CITY OF ALBUQUERQUE

PLANNING DEPARTMENT – Development Review Services

RE: GAHP Casa Feliz (L19D073A through L19D073I).
Grading and Drainage Plan
Engineer Stamp Date: 11/18/15

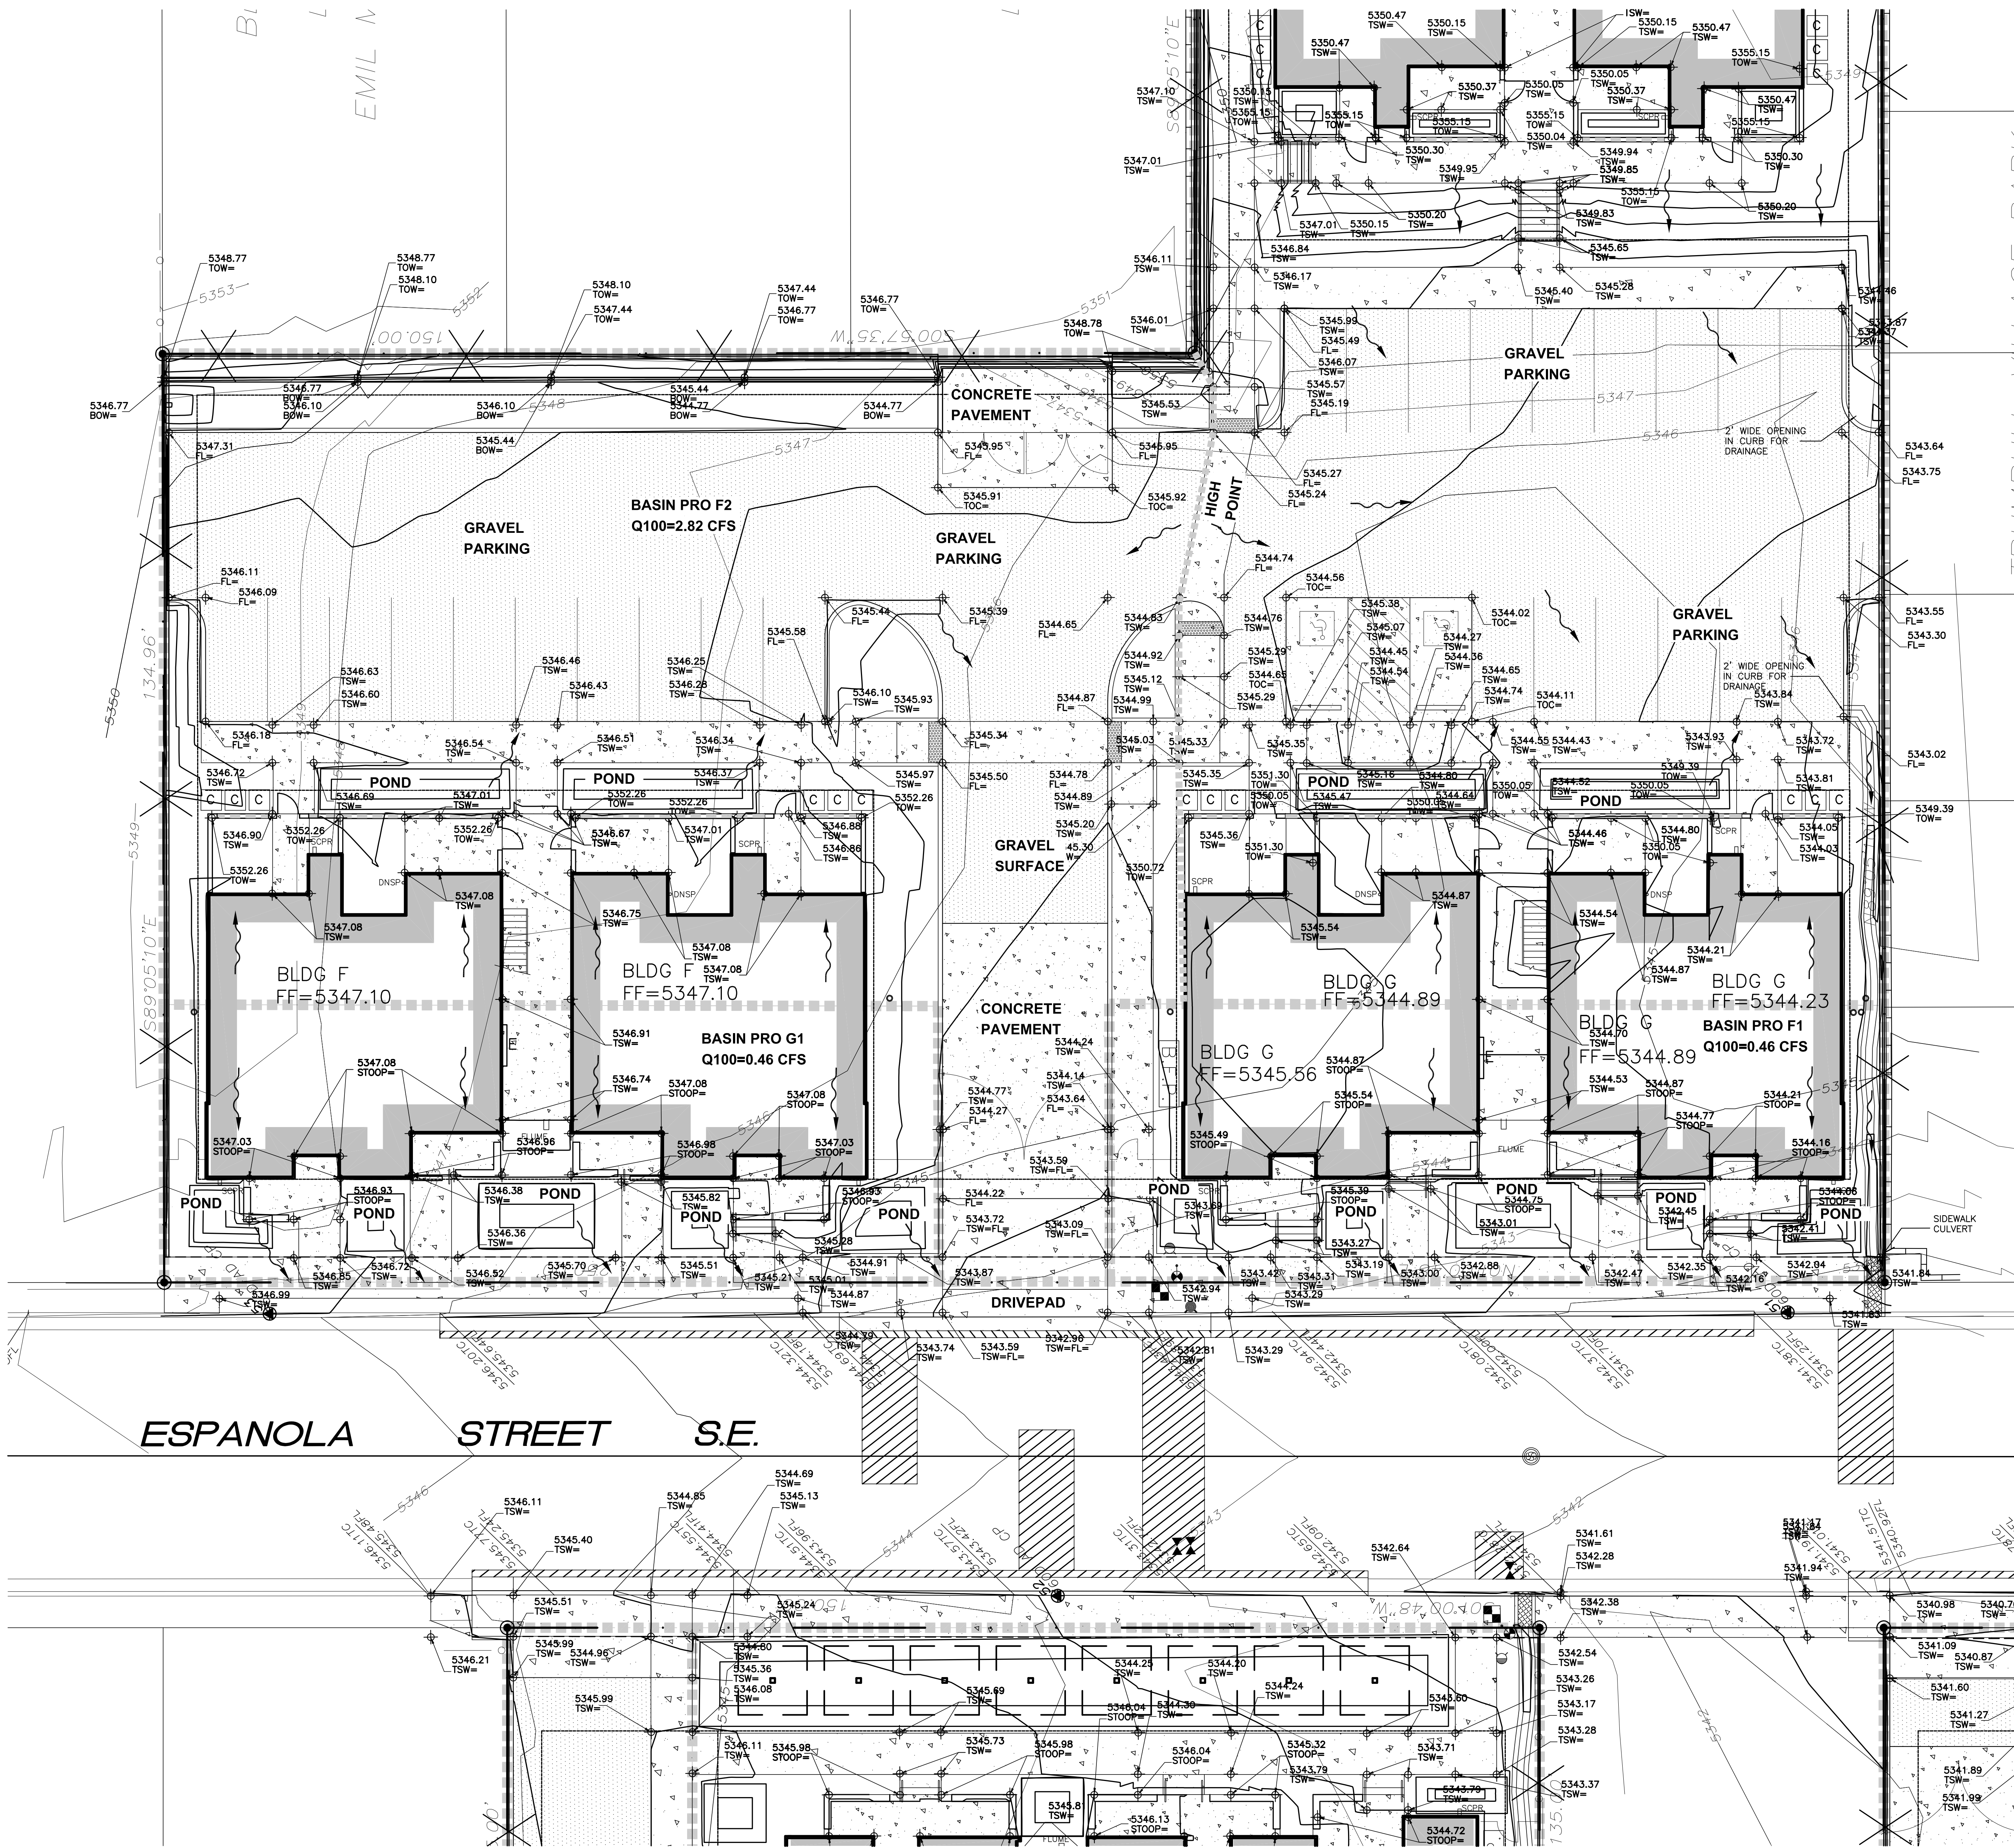
Sheet C207:

- Provide section through rip-rap channel on south side
- Remove ponding area on NE corner of site so that channel can pass to discharge to SW culvert at south end of landscape strip.
- Indicate both existing and new retaining walls (prefer to see it hatched so as to delineate it from a curb). Show TOW/BOW elevations for both.
- In front of Bldg G, shift SW culvert north so that landscape strip can discharge thru the culvert.
- Note that the SW culvert is to be constructed per work order.

A1 ENLARGED SITE DRAINAGE PLAN - BUILDING H

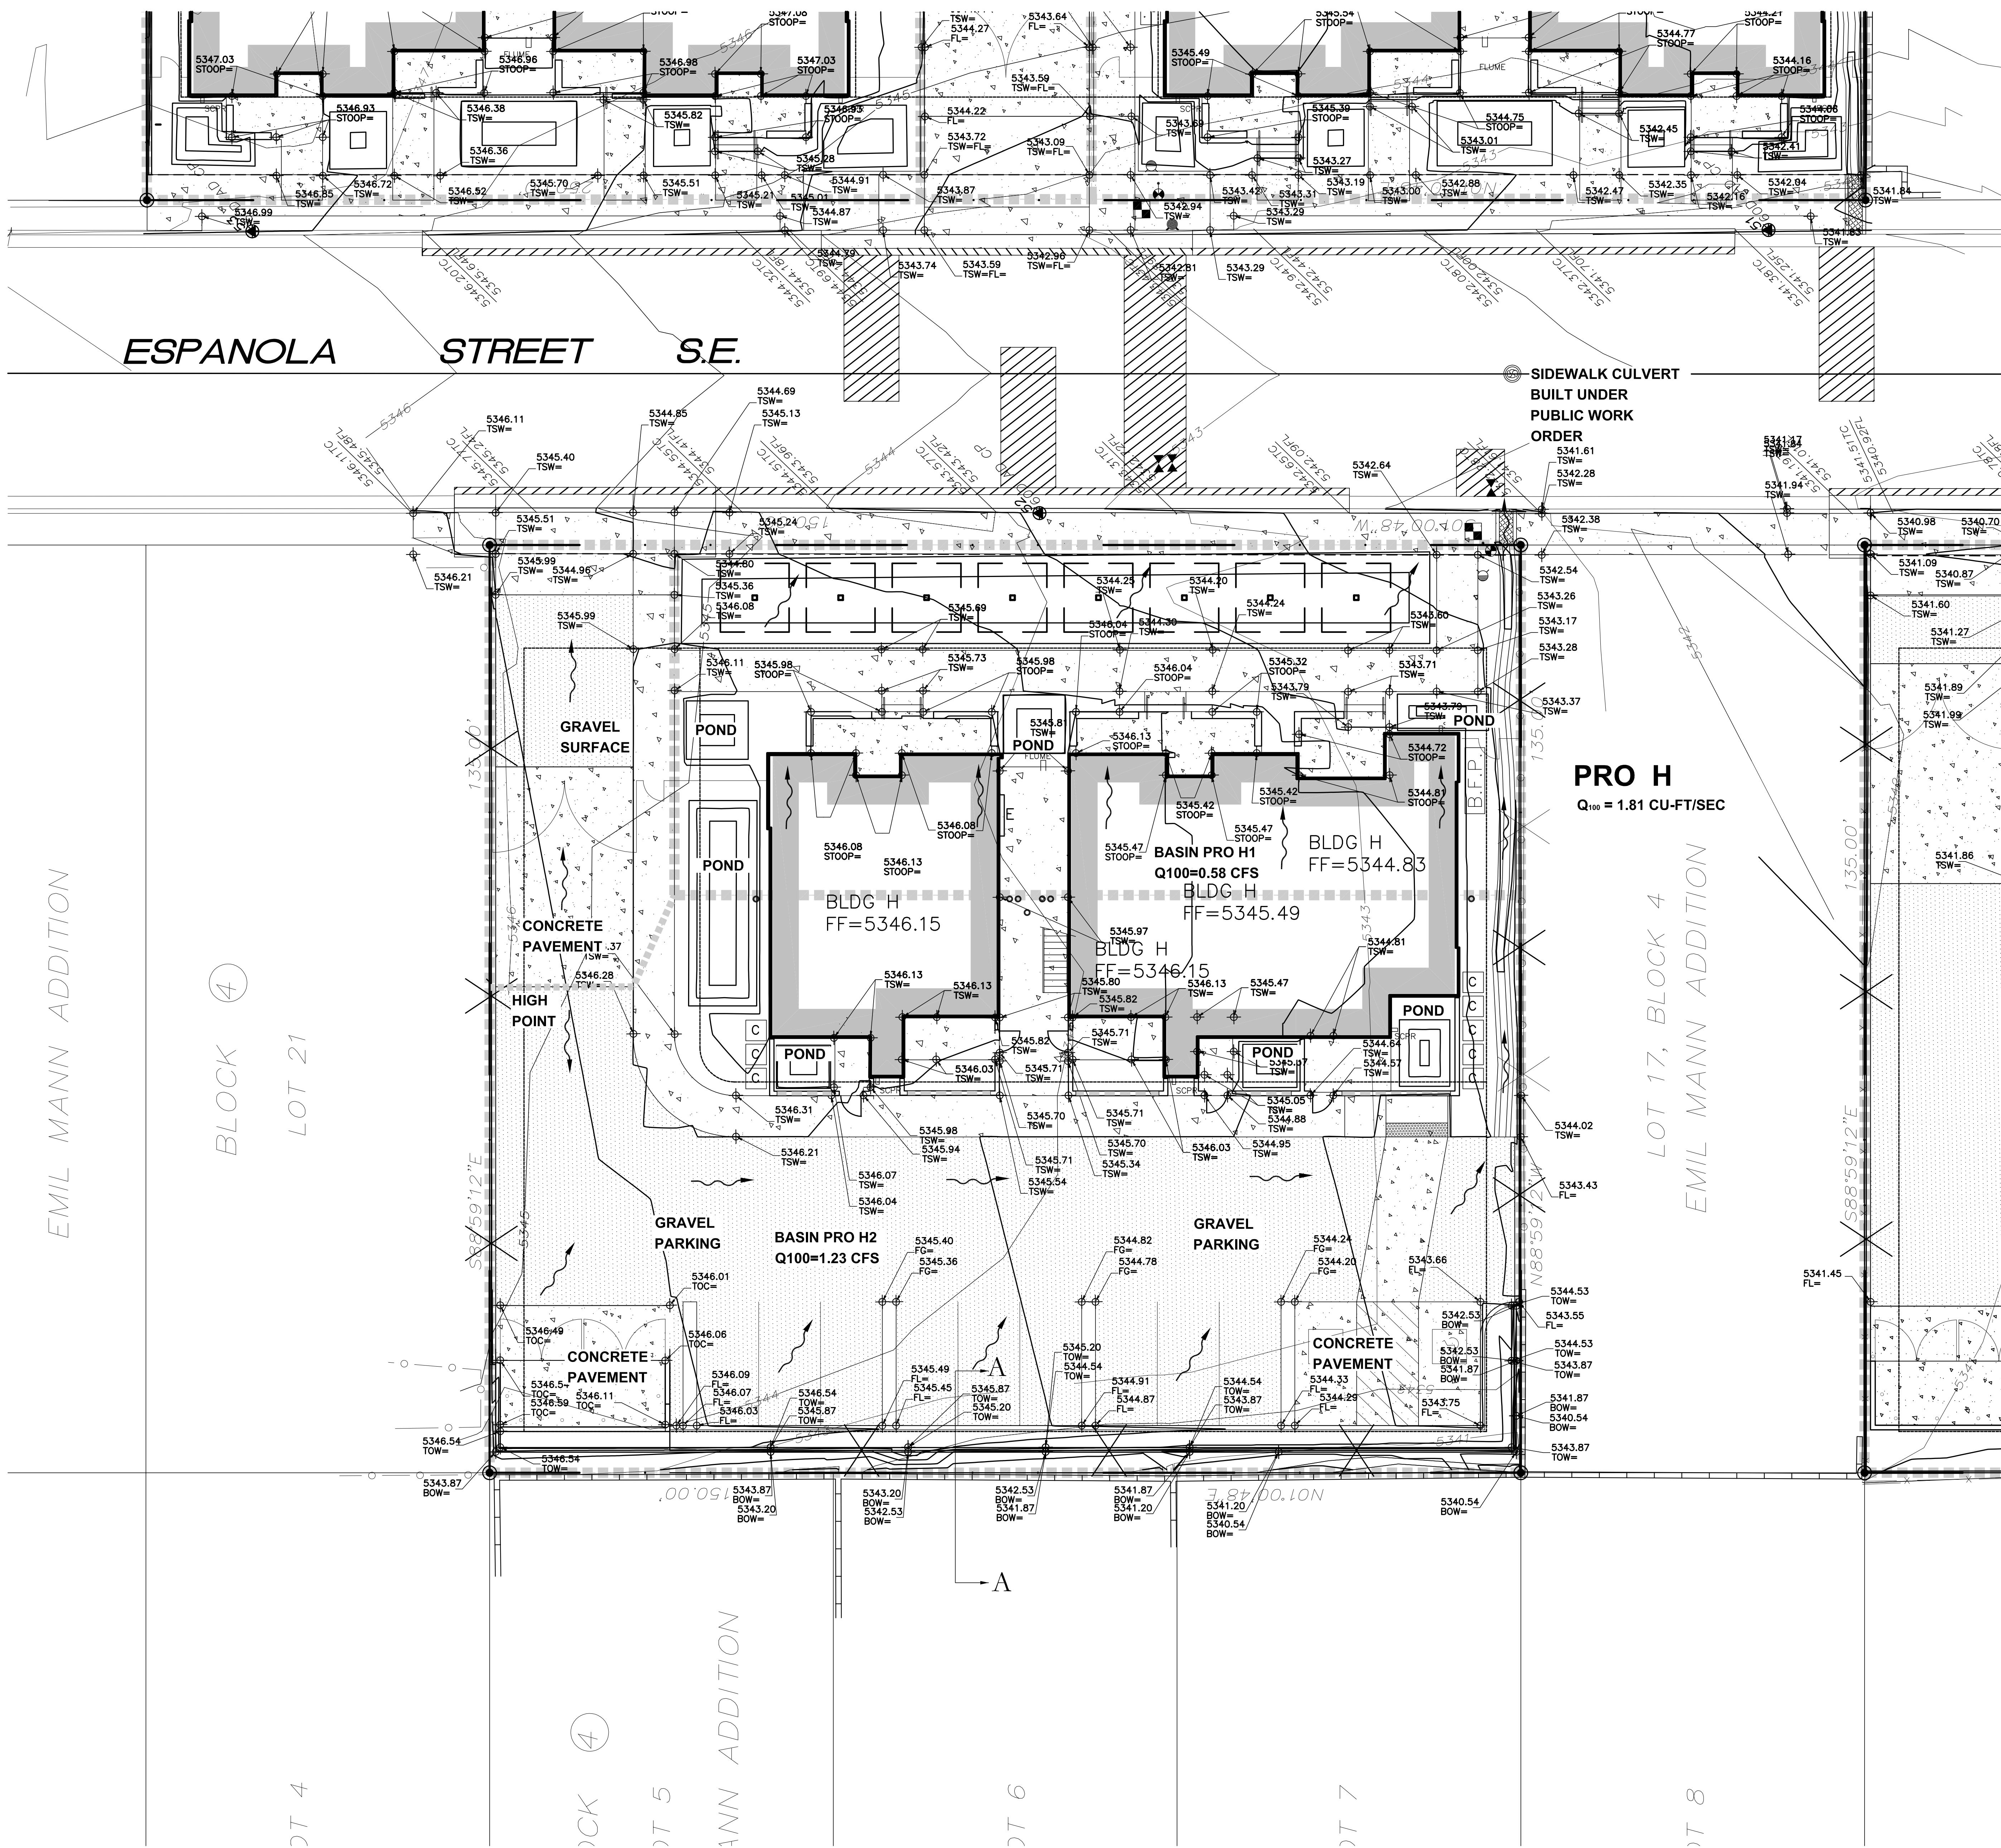
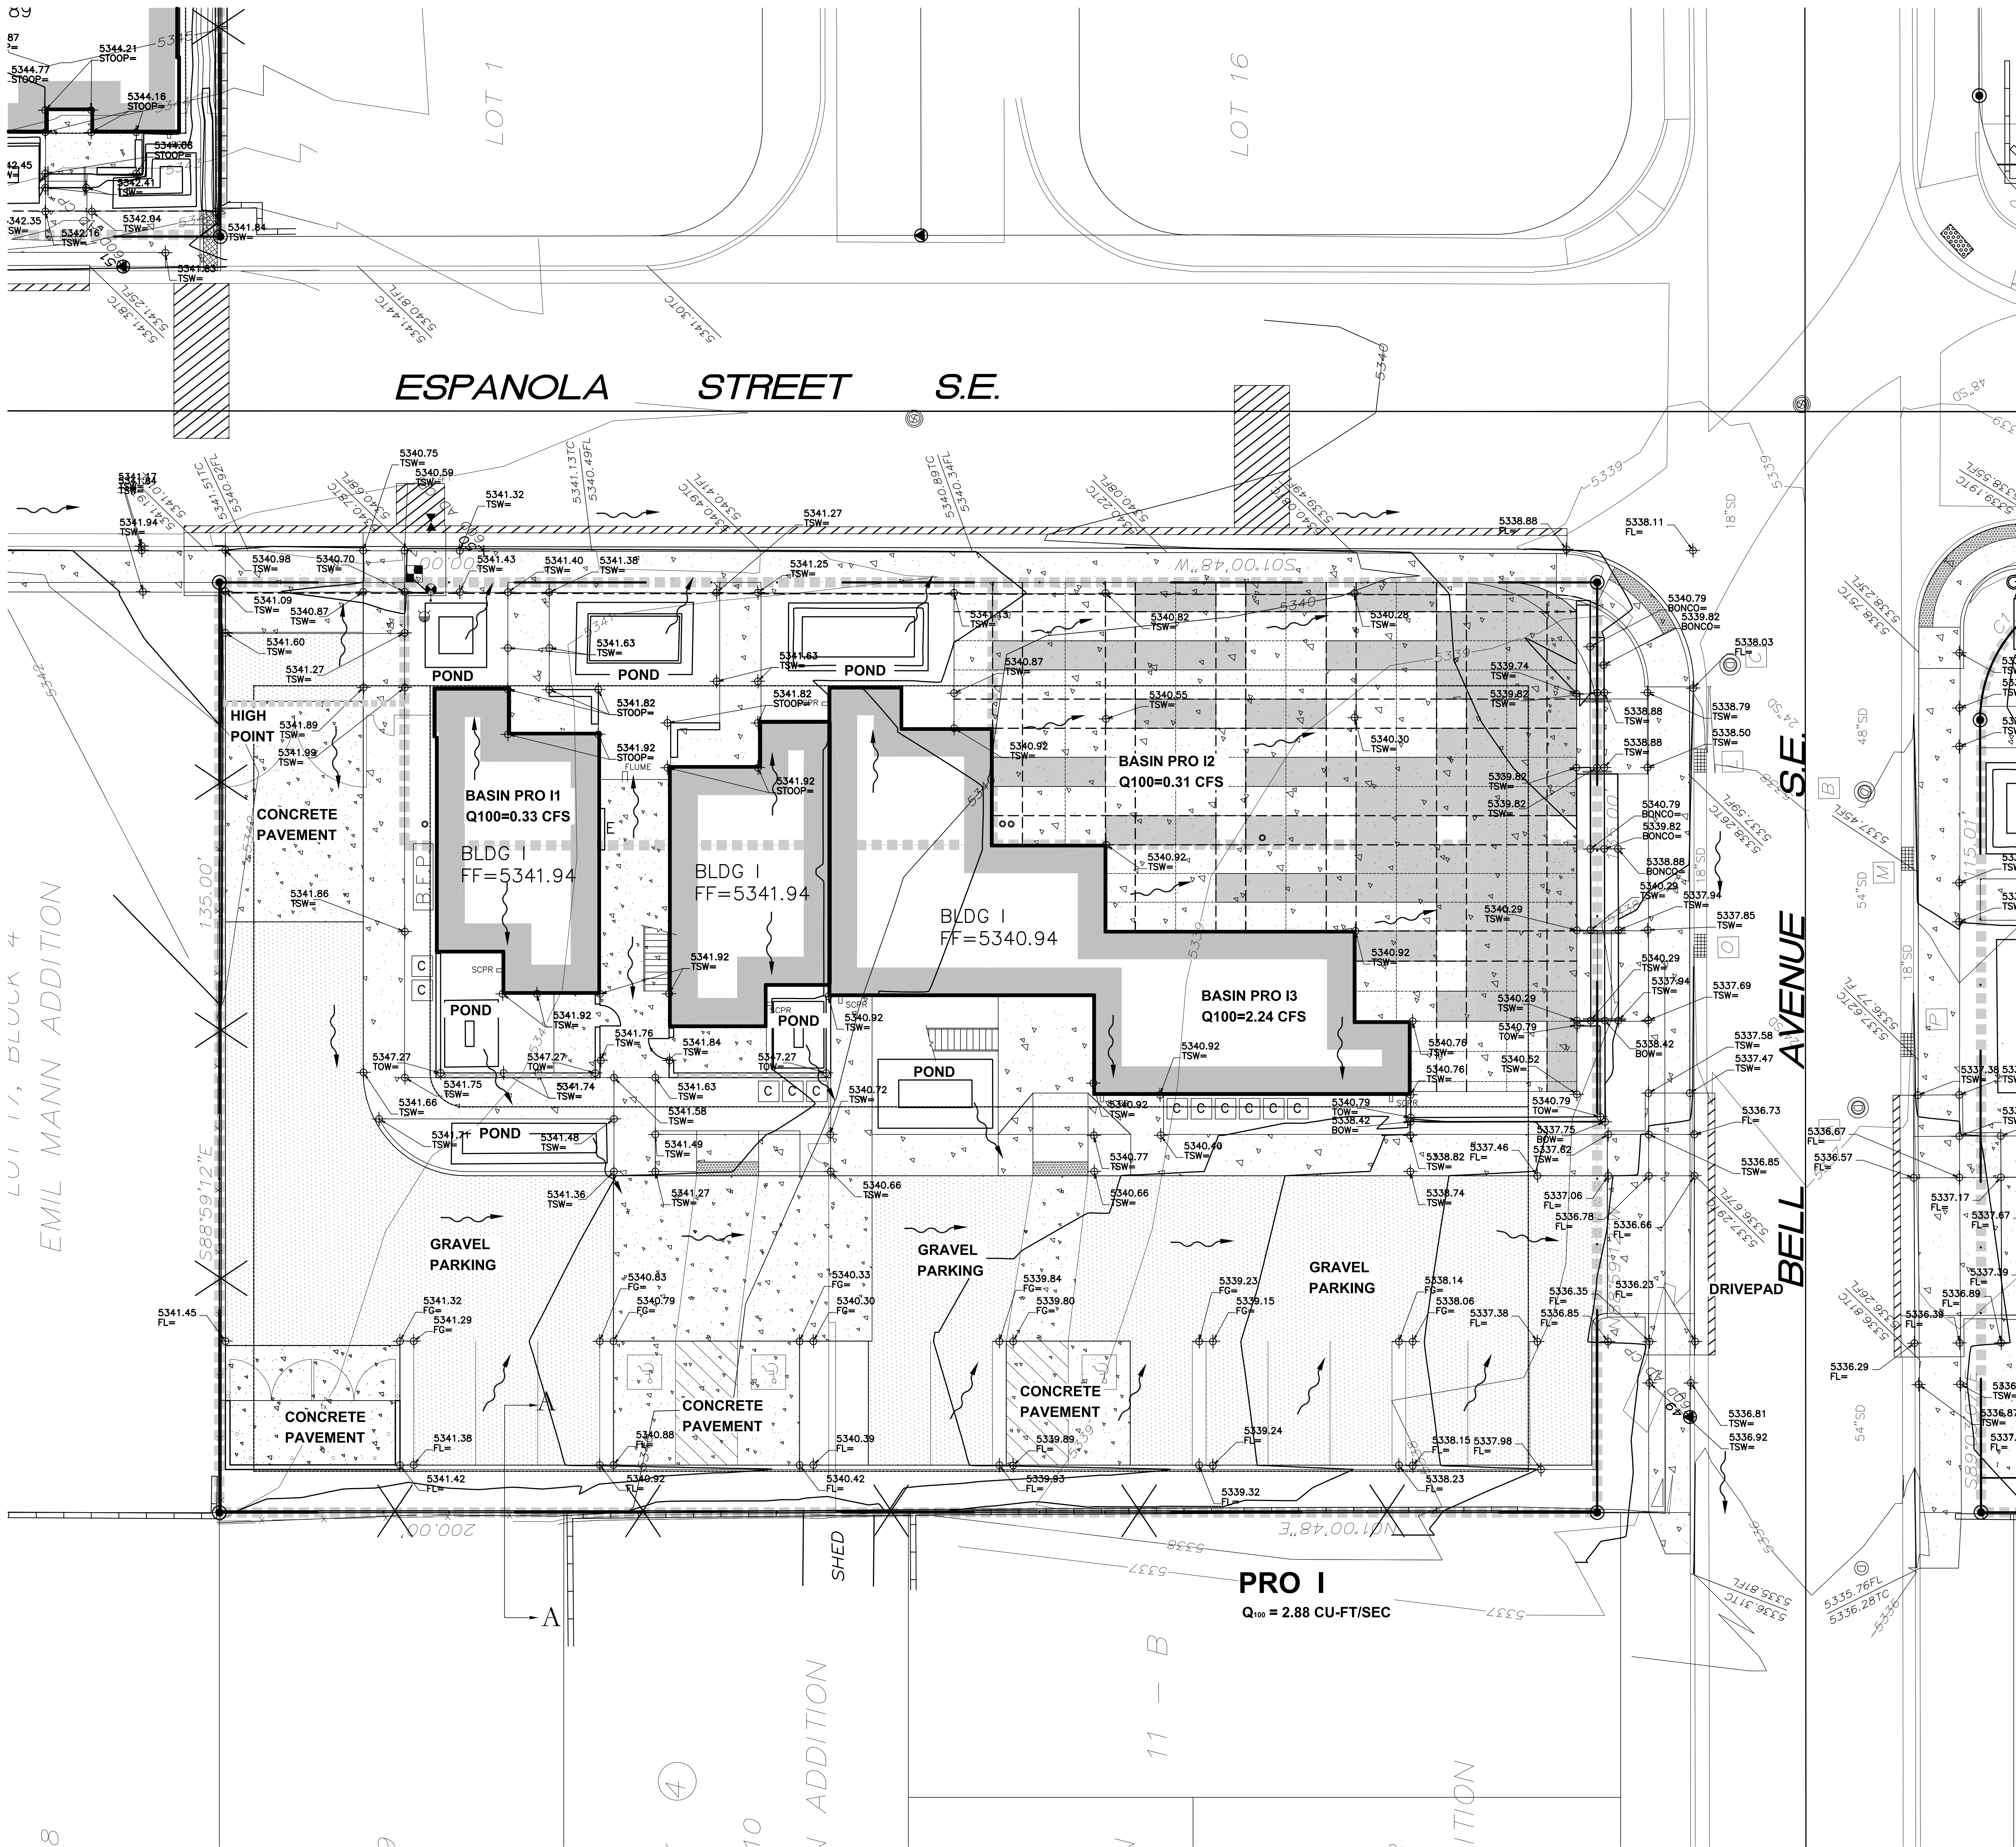
Bldg H (L19D073F, DRB # 1010666) Sheet C208:

- Provide a section thru canopies, pond, and curb and gutter at east side of site
- Show spot elevations at corners of ponds. Show how ponds will discharge once filled.
- Show section thru channel on south side.

- Reduce size of ponds so they are at least 5' away from building. Keep ponds shallow so as not to retain substantial amounts of water. First flush volumes may be reduced due to gravel used as parking lot paving.
